From: Simon Davis
Sent: Wednesday, February 7, 2024 3:39 PM
To: [REDACTED]
Subject: RE: BR/97/22/PL Royal Bay

From: Simon Davis
Sent: Monday, February 5, 2024 12:48 PM
To: [REDACTED]
Subject: BR/97/22/PL Royal Bay

Pagham Agreement

PROPOSED GROUND FLOOR PLAN (1:200)			
project	221	drawn	SG date 03.09.2020
revision	r02	checked by	date
scale @ A4	1:200	authorised by	date
drawing number	20200903_273_royal-bay_proposed-ground-floor-plan-r01_SG		
DWG file name	20200611_273_royal-bay_master-layout-r00_SG

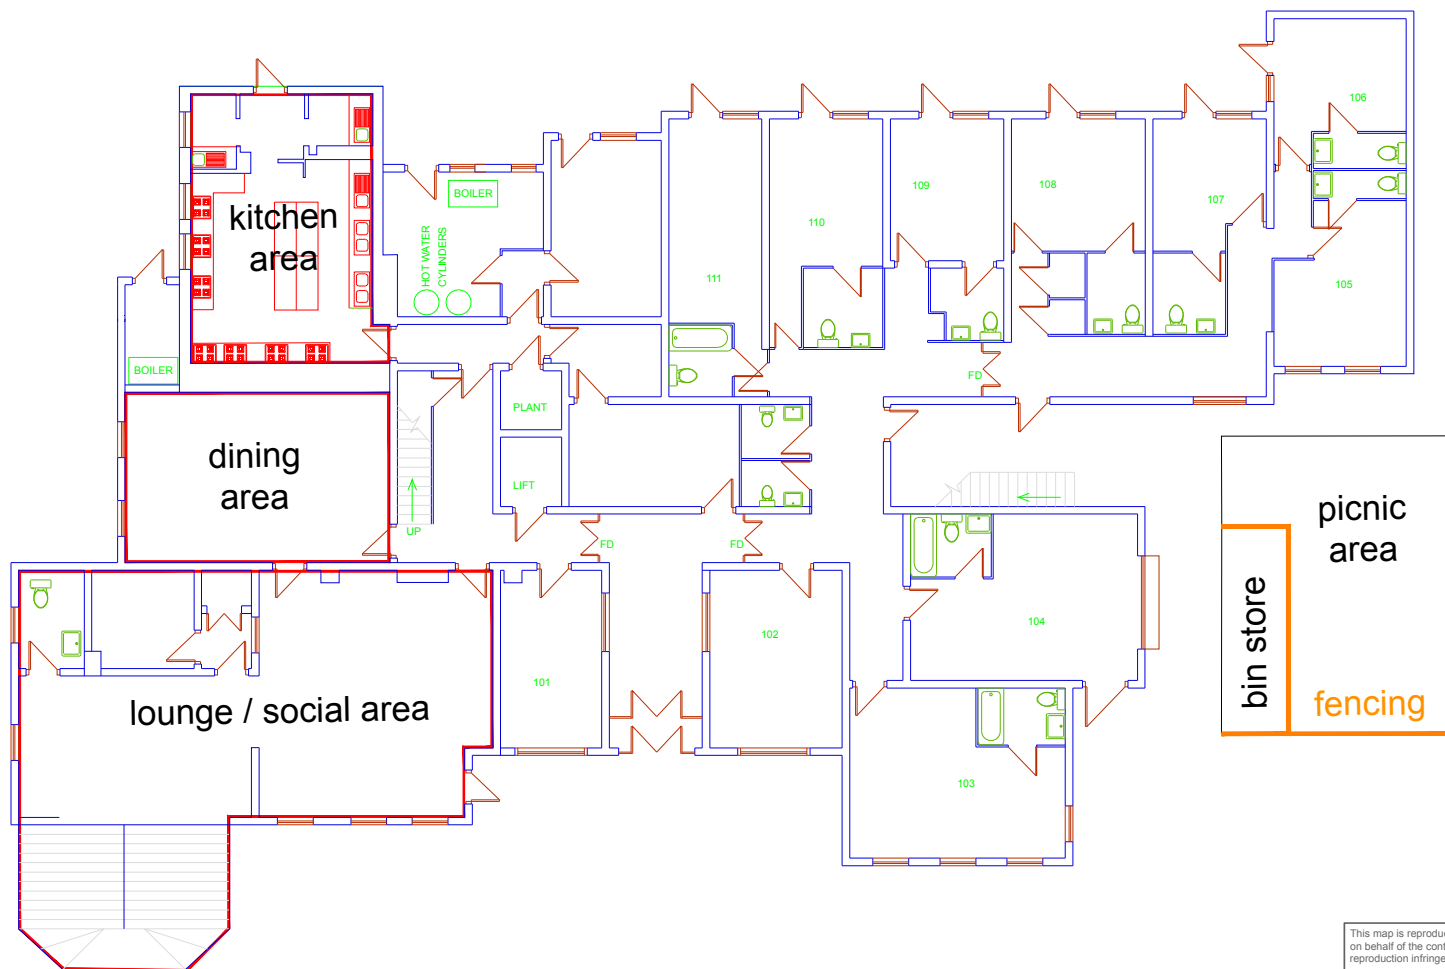
We require a Pagham Agreement for HMO uses as they are a form of residential use. Our standard way of calculating the contribution is to treat every 3 HMO bedspaces ~~rooms~~ dwellings as 1 'dwelling'. Your application is for 58 HMO bedspaces ~~rooms~~ and 2 live-in members of staff. As it appears that the 'staff' rooms are the same format as the HMO ones (there is nothing on the plan to differentiate this/these) then I

Royal Bay (Application Reference BR/97/22/PL) - External Amenity Areas

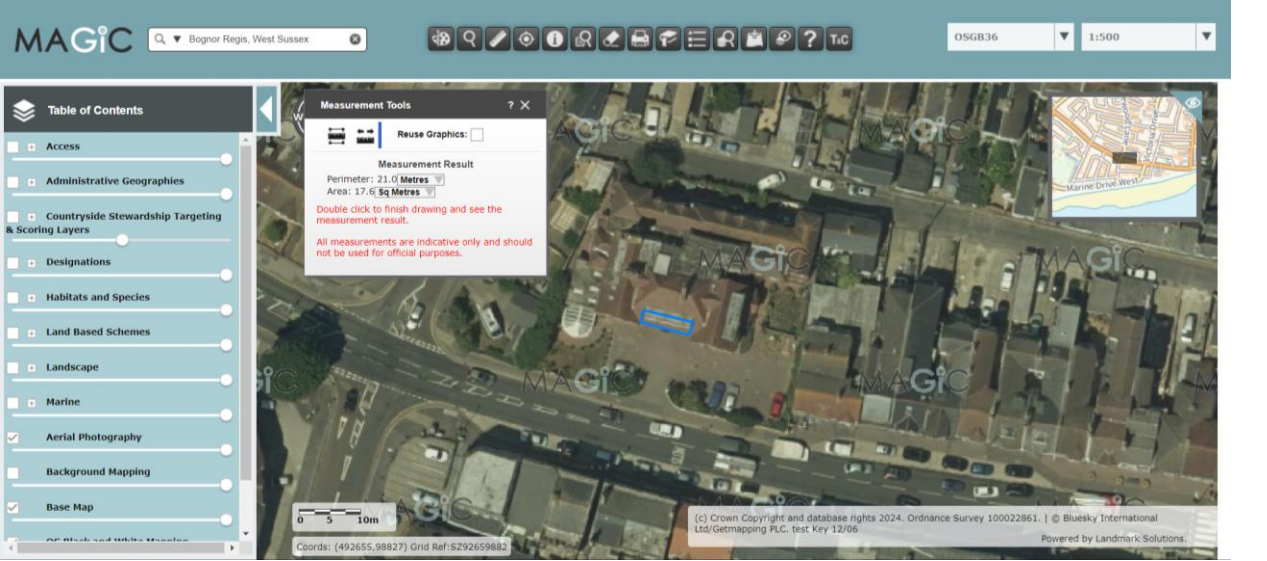
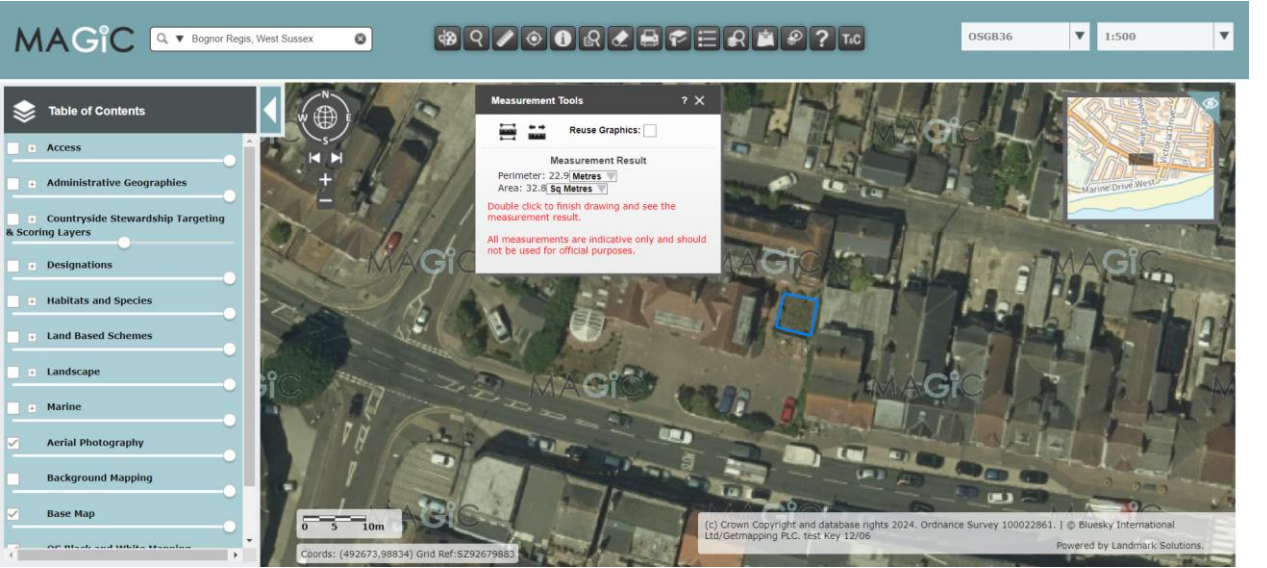
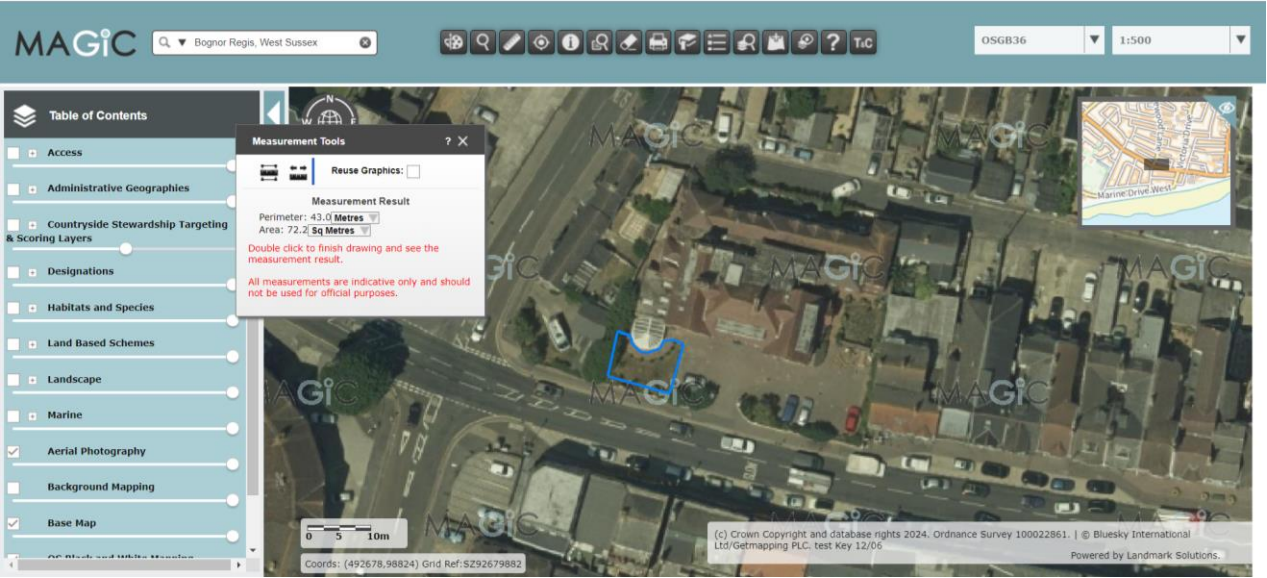
I have spoken to my Team Leader regarding the amenity space issue. We have had regard to your comments on the space available, the quality of the spaces, the proximity to nearby public recreation areas and the recent appeal decisions. In conclusion, we can agree that the space the site offers is acceptable but provided you can supply us with a plan which we can put on the file that clearly shows the 133m2 that is claimed. Whilst, we have identified the areas you talk about, the plan you provided to Maria in September does not indicate all of these areas and is not to scale.

You have referred to the appeal decision at 83 Aldwick Road which stated 40m² should be the minimum communal amenity space. However, this was then also partly dismissed having regard to the quality of the space which was deemed too compact to be useable or enjoyable.

The appeal decision at Nyewood Lane referred to above ref Pagham Harbour also commented on this matter and made reference to some previous decisions where a lower m² of space per person had been accepted by the Council. The m² for the appeal proposal was 3.56m² per resident which exceeded some other sites including Ashley House (1.71m²) and indeed the temp permission for the Royal Bay Care Home (stated to be 0.7m² based on 41m²). It is unclear where the amount of 41m² comes from, but it may represent the rear area which is a compact space. Even if I now take your figure of 133m², then the figure is 2.22m² which is lower than the appeal decision.

I agree that you meet the minimum amount per the 83 Aldwick Road decision however given the other appeal decision and the comments on the former regarding the quality of the space, this is not a clear-cut issue. I will need to speak with my manager about this to agree our position.
